Application Ref:	3/2025/0377				Ribble Valley Borough Council www.ribblevalley.gov.uk
Date Inspected:	20/6/25	Site Notice:	20/6/25		
Officer:	BT				
DELEGATED ITEM FILE REPORT:				Decision	REFUSAL

Development Description:	Prior approval for the proposed change of use of a former agricultural building to one dwellinghouse under Schedule 2, Part 3 Class Q of the GPDO.
Site Address/Location:	Fields Farm, Mearley, Pendleton, BB7 1PU.

project	project number	drawing number
fields farm	25.07	PL.02
name proposed plans & elevations - barn		
scale	date	status
1 to 100 @ A1	may 2025	planning
		revision
		B

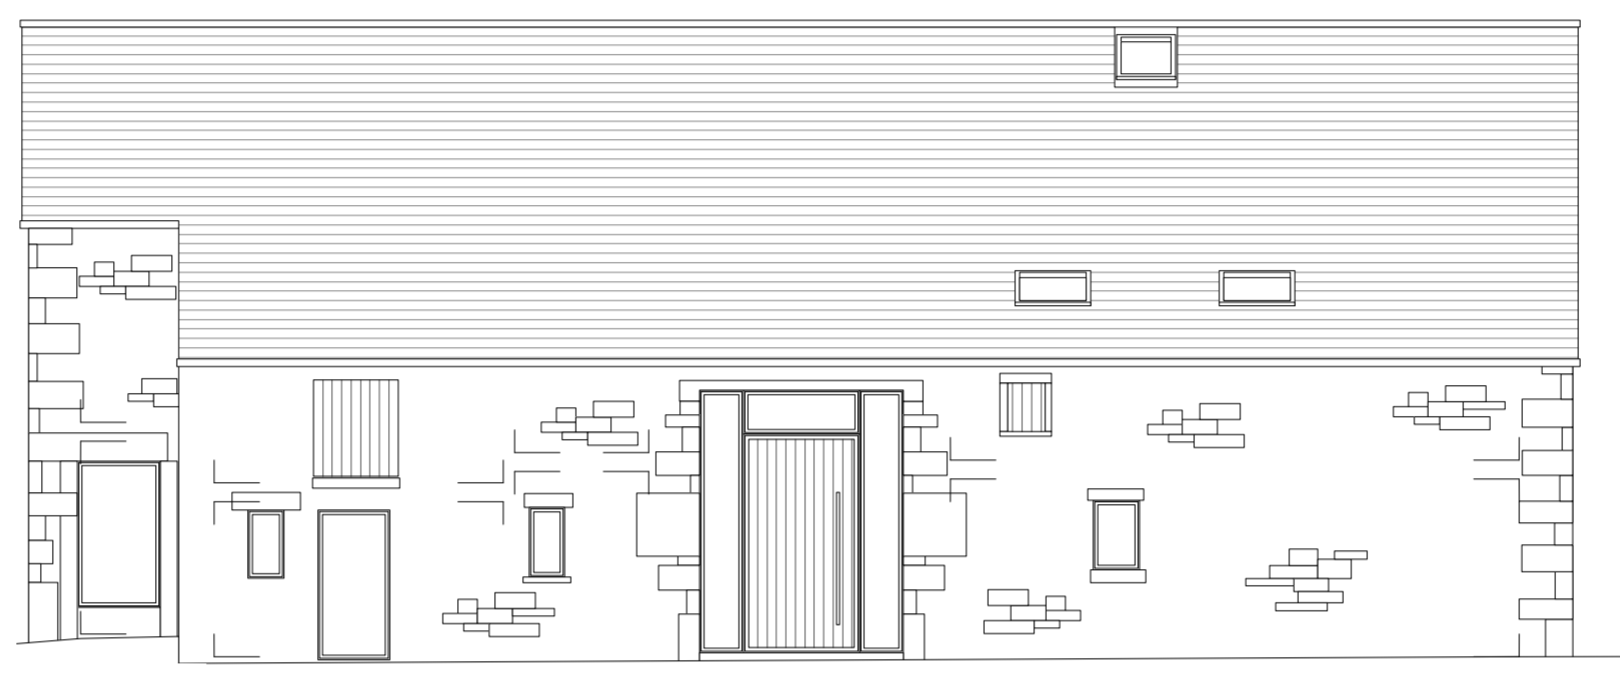
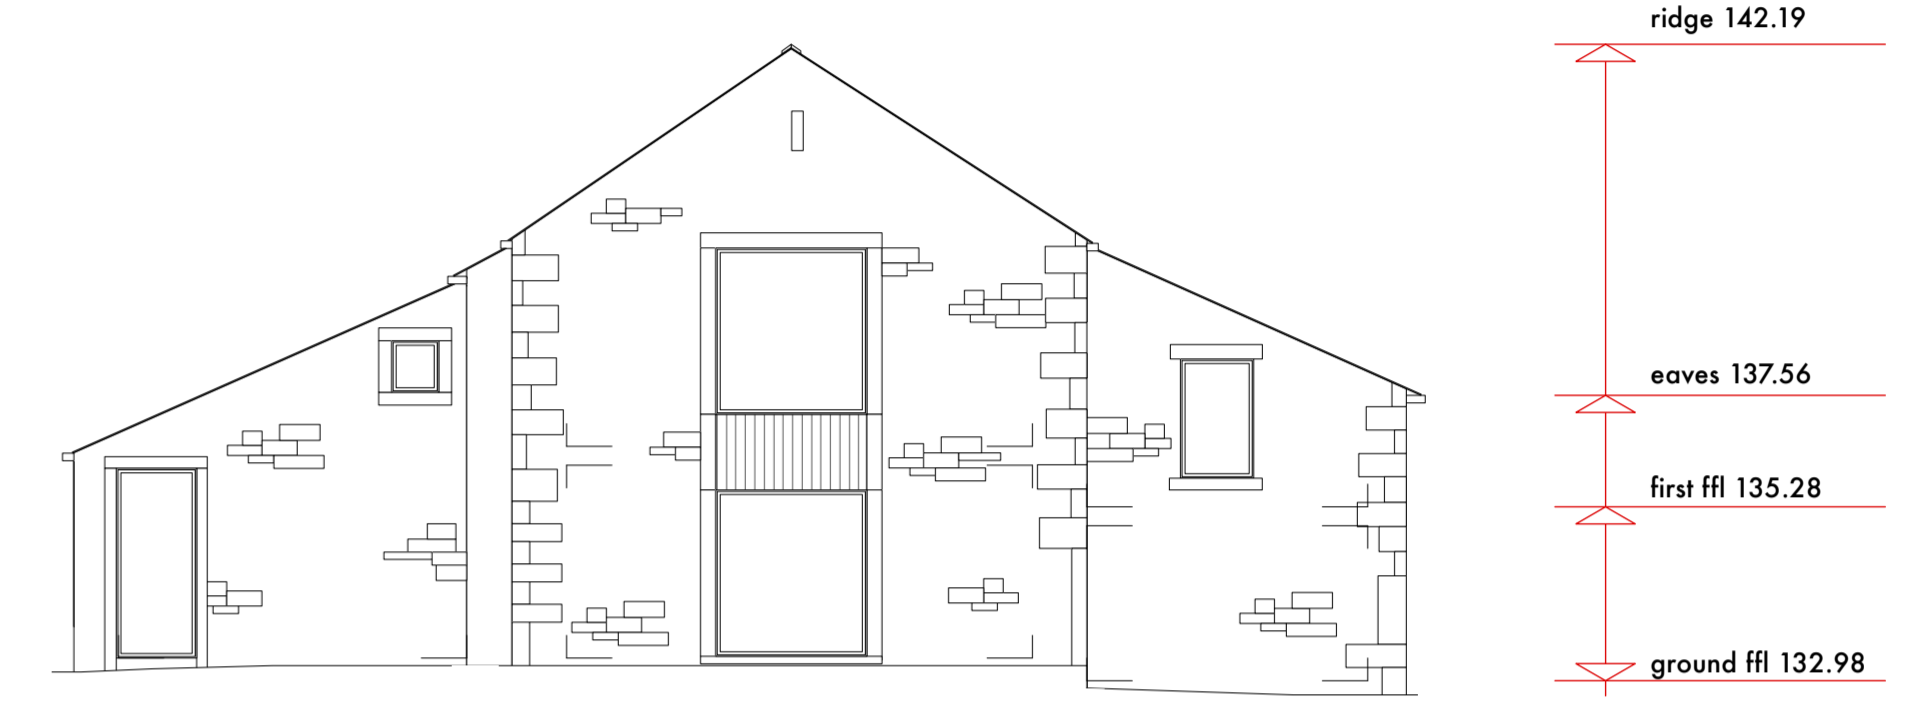
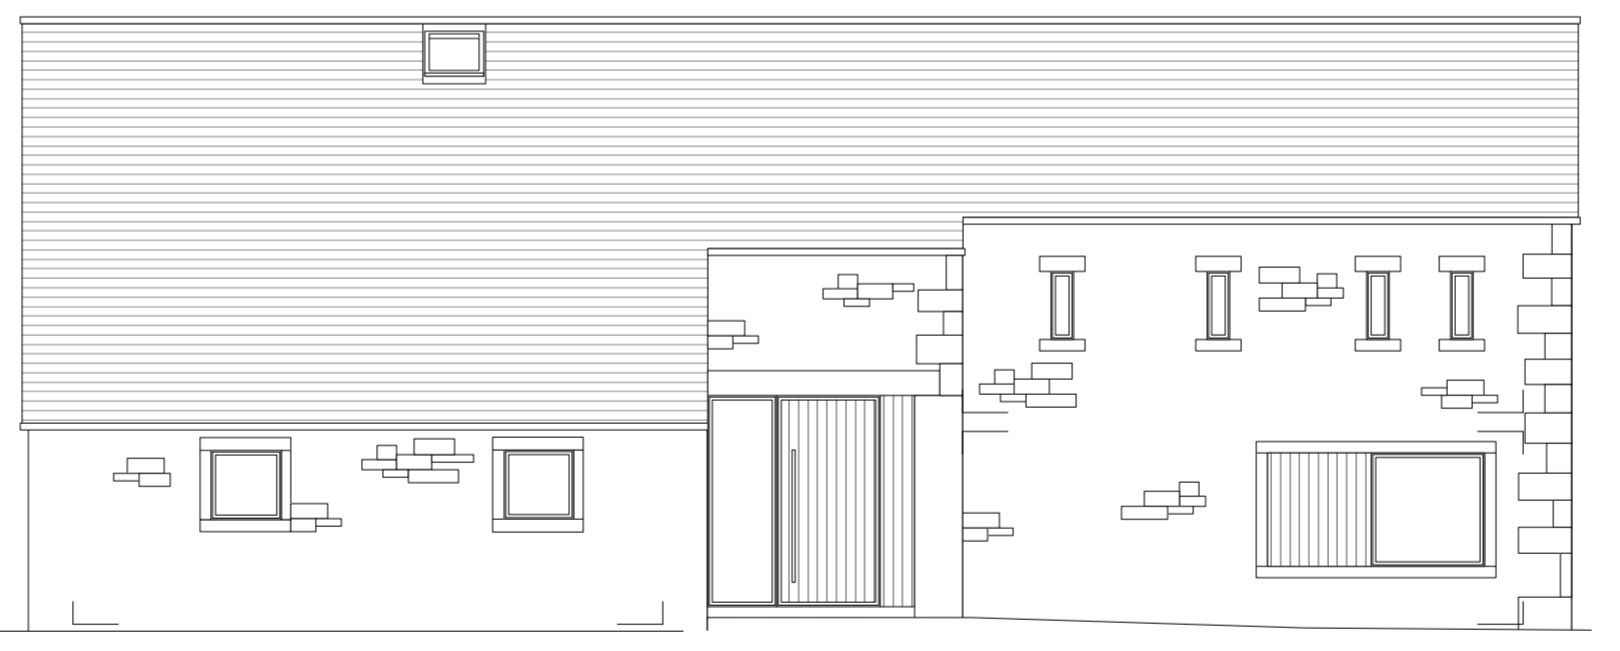
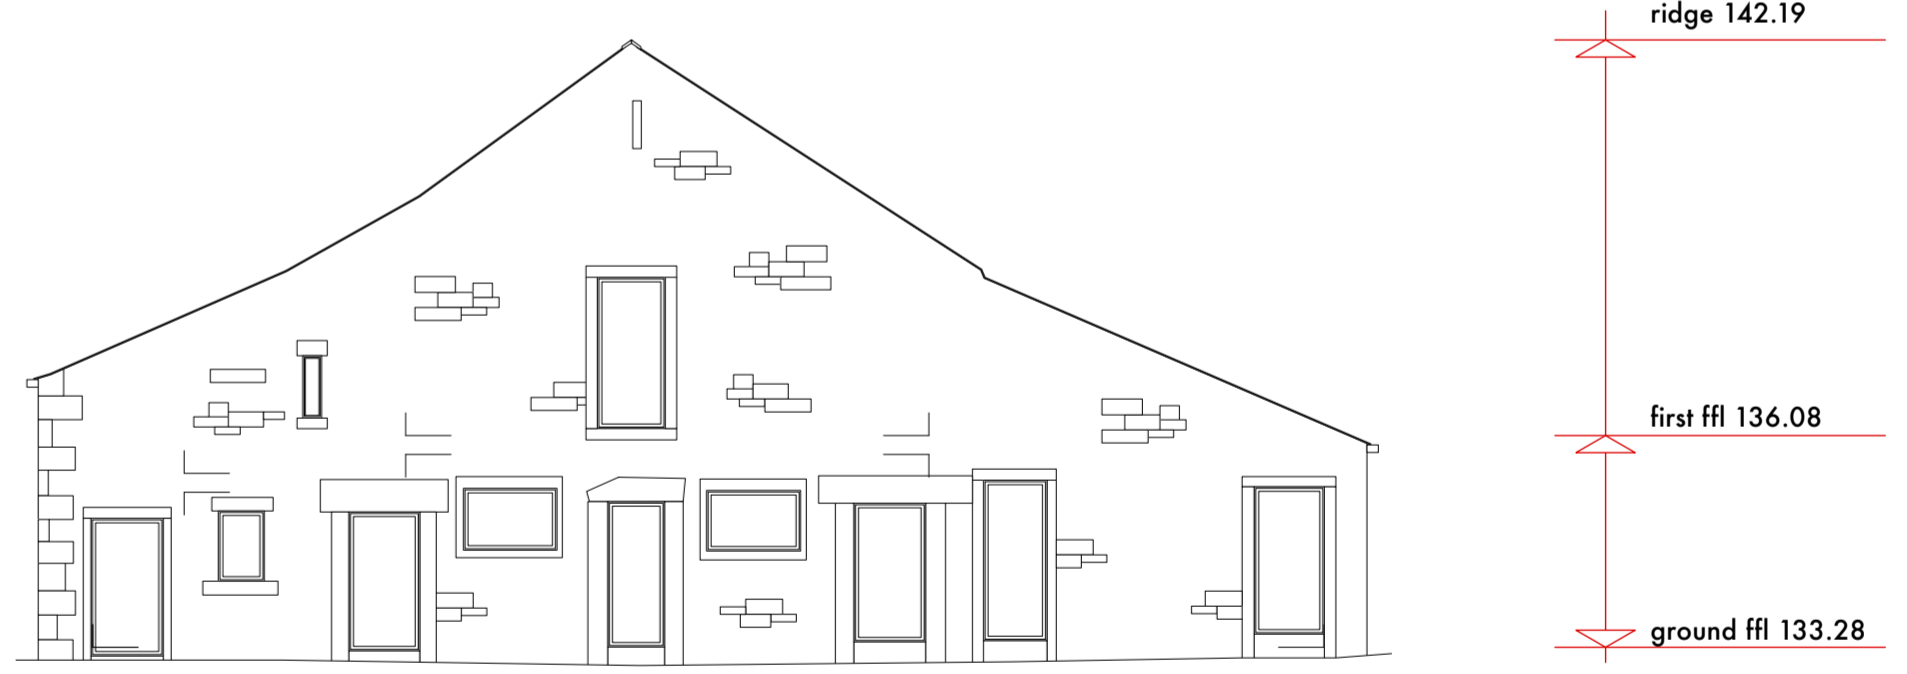
In this instance, the proposed scheme of residential conversion would make some use of the barn's existing openings however the proposal would also introduce several new elements to the traditional barn building in the form of large glazed openings to the building's North-western and South-eastern gable ends and a horizontal half boarded opening to the building's North-eastern elevation, all of which would be noticeably at odds with the proportionality of the building's existing sequence of openings. Furthermore, new rooflight openings would be introduced to the barn, one of which would serve a non-habitable room and two of which would be sited close together in a cramped spatial arrangement directly below the roof ridge of the building. As such, the resultant dwelling, by virtue of its fenestration, would appear overtly domestic in appearance which in turn would be at odds with the agricultural character of the historic barn building, application site and rural vernacular of dwellings within the immediate and surrounding area.

Accordingly, the proposal is not considered to amount to a visually sympathetic form of development with respect to its design and external appearance. Prior approval is therefore required and refused on this matter.
